Recommendation Report for Planning Permission for Works or Extension to a Dwelling

REF NO: R/13/18/HH

LOCATION: 84 North Lane
Rustington
BN16 3PW

PROPOSAL: Two storey side & rear extensions. Resubmission of R/55/16/HH

Tel:- 01243 555208 enquiries@extendinghomes.co.uk	
TITLE:- Renovations to 84 North Lane Rustington West Sussex BN16 3PW	
DATE:-	8th December 2017
SCALE:-	Elevations 1-100
DRAWN:-	P.Robinson
DWG. No. 1712081/PL/1A

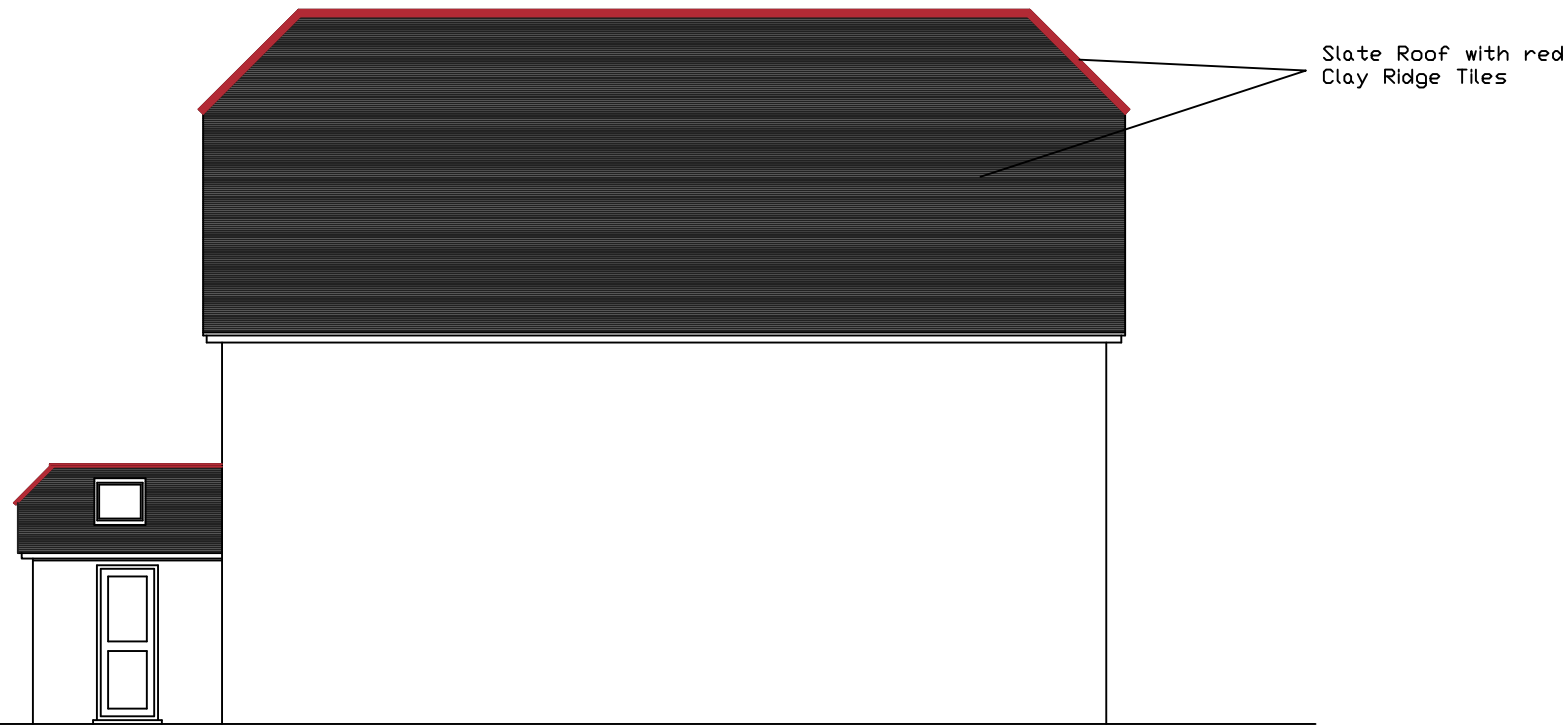
The proposed extensions and alterations significantly alter the shape of the building. However, change is not necessarily harmful in itself. There is an increase in ridge height of the property and together with an overall increase in the bulk of the building. It is noted that the proposed development has attempted to reduce the bulk of the front and rear elevations with the introduction of two small bonnet hips. The proposed resultant building would be readily visible from the street. Therefore, the extensions and alterations as a whole alter the design, scale and bulk of the original property. It is accepted that there is a variation in the scale and form of properties along this part of North Lane and also that national guidance in the NPPF states "planning policies and decisions should not attempt to impose architectural styles or particular tastes and they should not stifle innovation, originality or initiative through unsubstantiated requirements to conform to certain development forms or styles. It is, however, proper to seek to promote or reinforce local distinctiveness". However, the style of the resultant property is different and is not subordinate to the original house and the increase height and size of the proposed roof does accentuate the bulk of the building.

In addition the proposed building will effectively fill the whole width of the plot. It is noted that an attempt has been made to address this following comments from Officers and set the proposed building in form the south boundary. The resultant building would now be sited between approximately 1.2m and 1.8m from the south boundary and approximately 1.4m from the north boundary. However, it is still considered that the proposed development appears cramped on the plot. Other properties in the locality have greater space on the plot or involve a mixture of two storey and single storey heights.

As such it is considered the width of the dwelling in conjunction with the height of the proposed dwelling and the design proposed with a bulky roof is considered to result in a dwelling which appears bulky and out of character with the locality of the site.

The proposal by virtue of its design and size will have a dramatic impact upon the appearance of the host dwelling and as such is not considered to be subservient or sympathetic to the scale, appearance and character of the host dwelling. Therefore, the proposed alterations are considered to conflict with policies GEN7(ii), DEV19 (i) and (ii) of the Arun District Local Plan and policy 2 of the Rustington Neighbourhood Plan.

Tel:- 01243 555208 enquiries@extendinghomes.co.uk	
TITLE:- Renovations to 84 North Lane Rustington West Sussex BN16 3PW	
DATE:-	8th December 2017
SCALE:-	Elevations 1-100
DRAWN:-	P.Robinson
DWG. No. 1712081/PL/2A

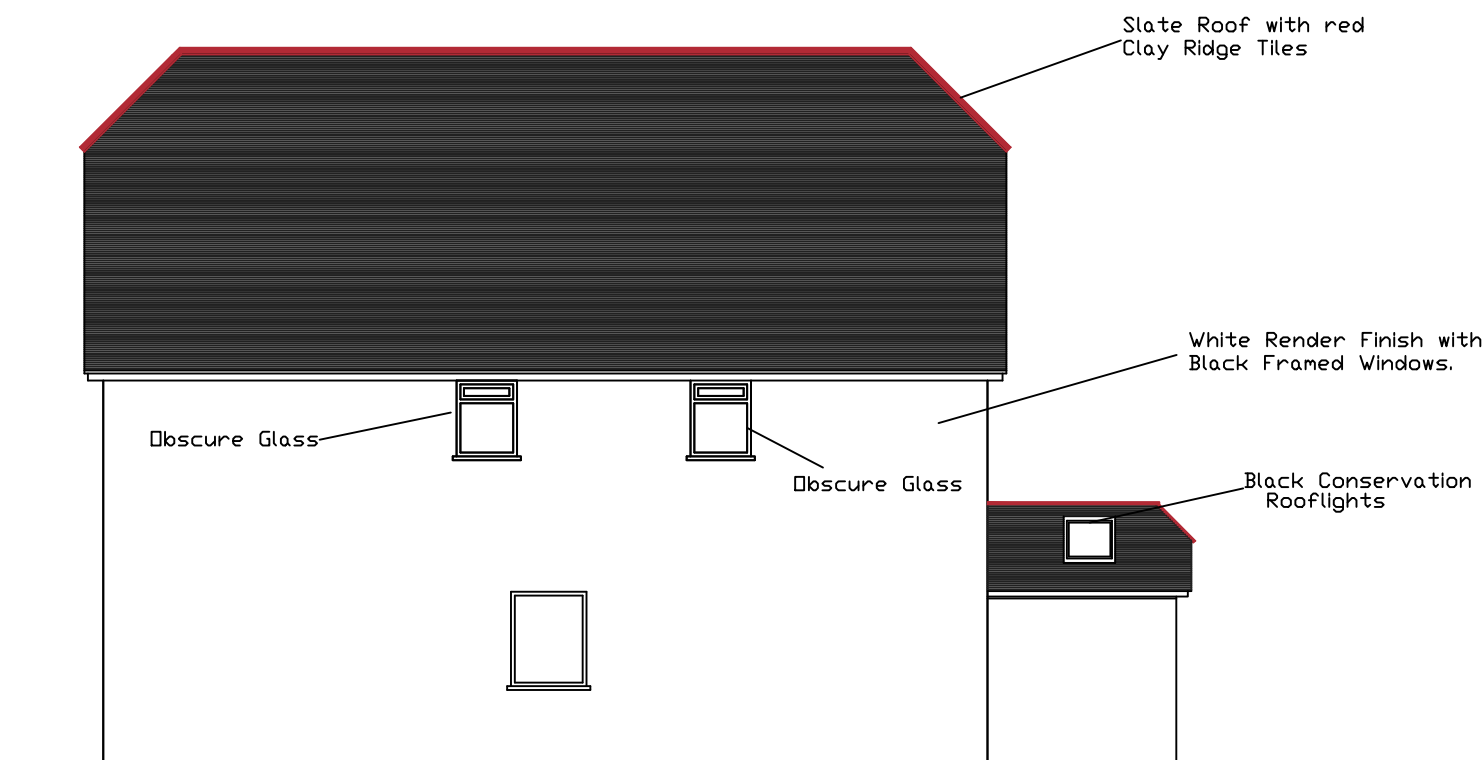
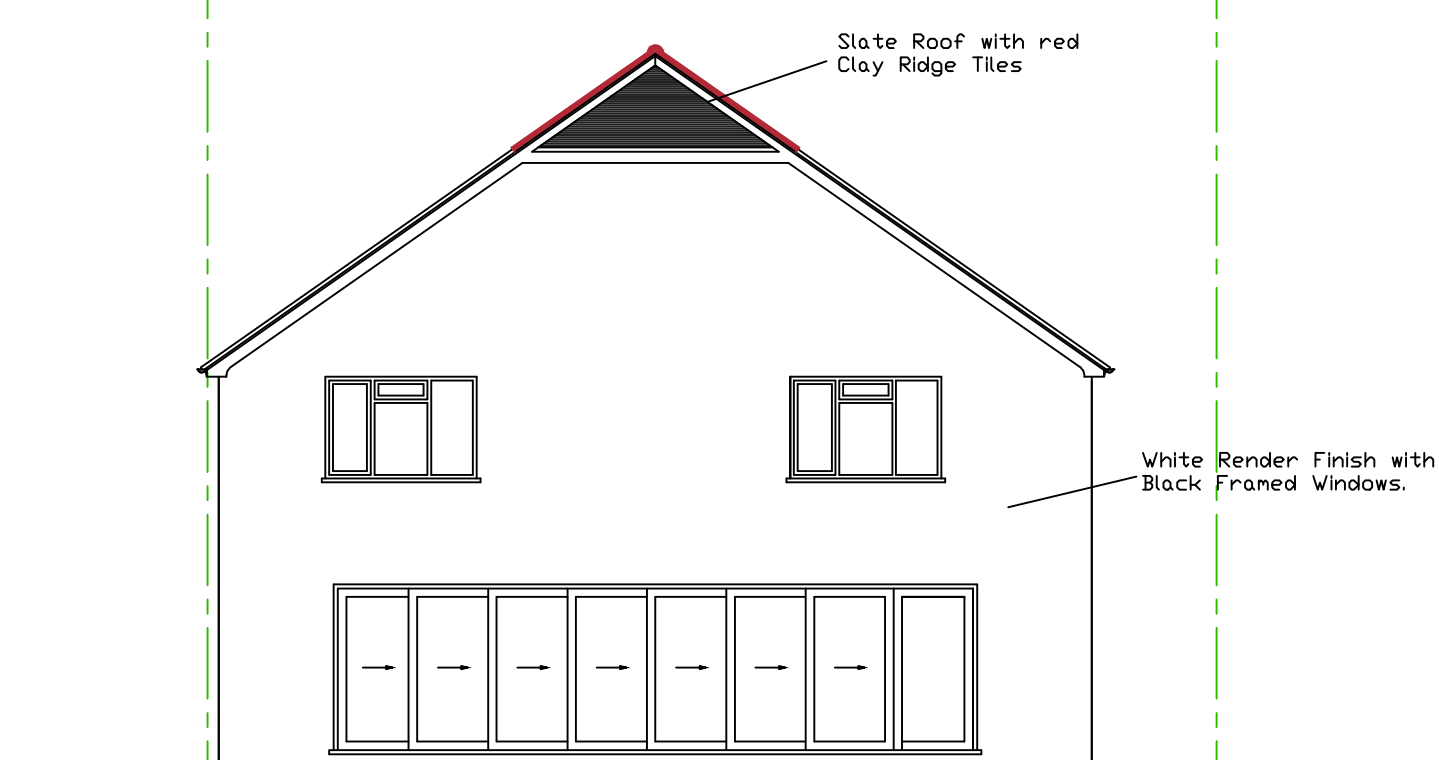
The proposed windows on the side elevation of the dwelling facing No.86 serve en suite bathrooms and could be conditioned to be obscure glazed if approved. There are no windows in the side elevation facing No.82. However, the rear first floor bedroom window would be approximately 2.4m from the side boundary with No.82 and given this close proximity to the boundary there would be views from it of the rear garden of number 82. This constitutes unacceptable overlooking and as this is the only window serving this room a condition to fix shut and make the window obscure glazed to prevent unacceptable overlooking could not be reasonably imposed.

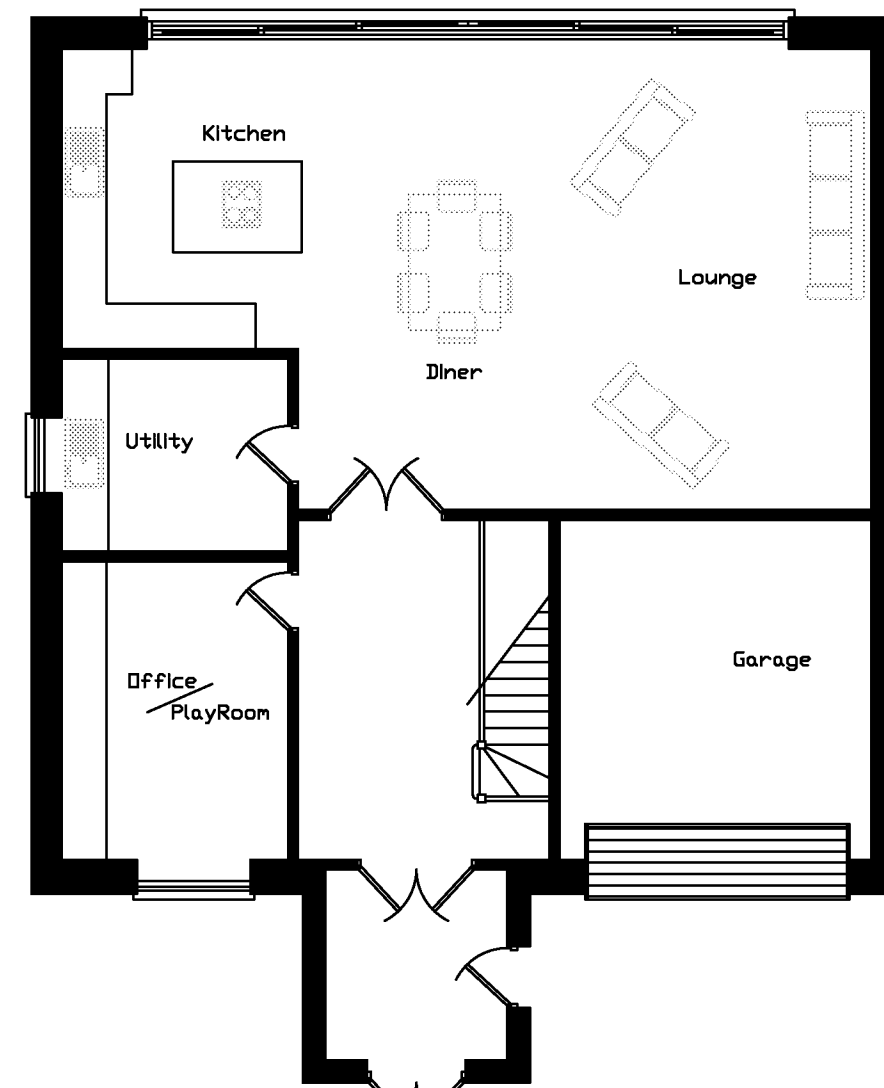
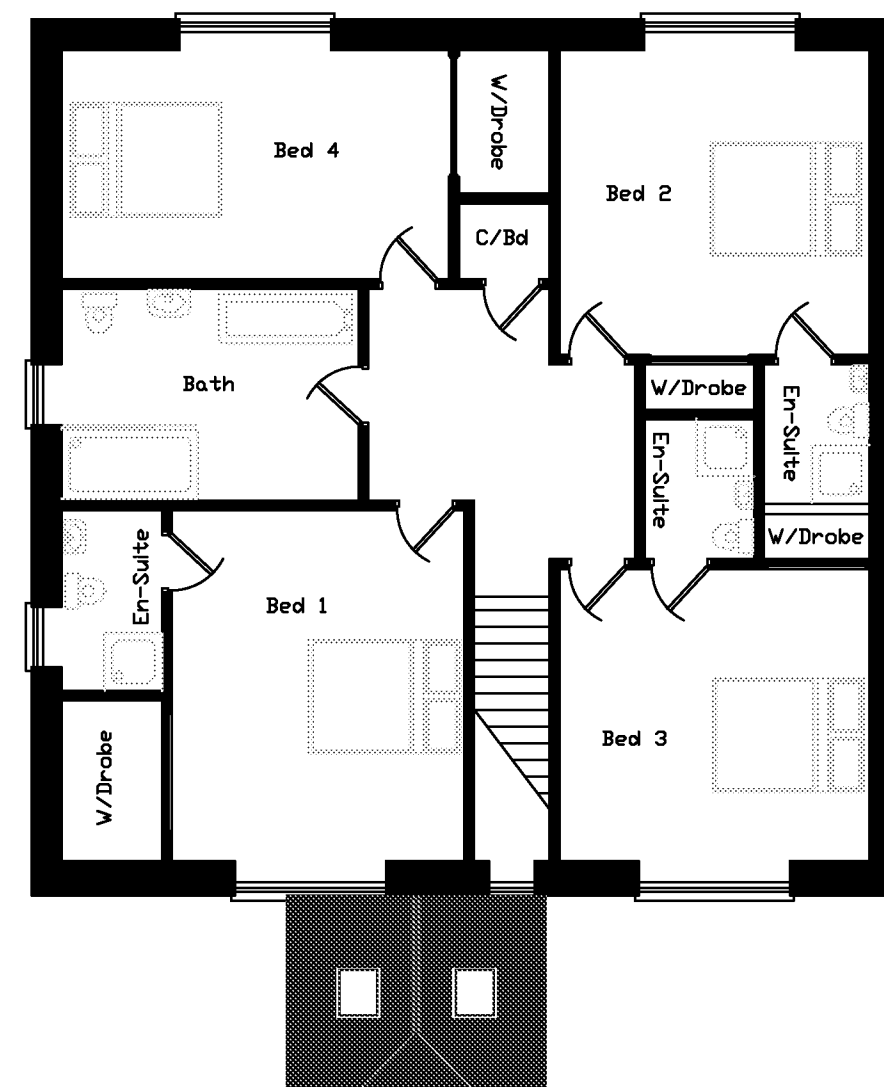
With regard to residential amenity. The proposed alterations will be located 1.4m from the northern boundary and between 1.8m and 1.2m from the southern boundary of the site. The current proposal has been set back further than the previously refused scheme. Its rear elevation is in line with the rear elevation of the property to the north No.86. As such although there is an increase in height it is not considered that the proposed development will be unduly dominant upon or lead to a loss of outlook to the occupiers of this property. With regard to No. 82 to the south although the proposed development will extend approximately 4m beyond the rear elevation of No.82 the Council have adopted a 45-degree rule as a tool to balance the interest of those persons wishing to extend their premises and their neighbours

- 2 The proposed siting and position of the rear first floor bedroom window will lead to an unacceptable level of overlooking of the garden of No.82 North Lane leading to a loss of privacy to the occupiers of this property in the use of the garden area in conflict with policies GEN7 (iv) and DEV19 (iii) of the Arun District Local Plan, policy 2 of the Rustington Neighbourhood Plan and the National Planning Policy Framework
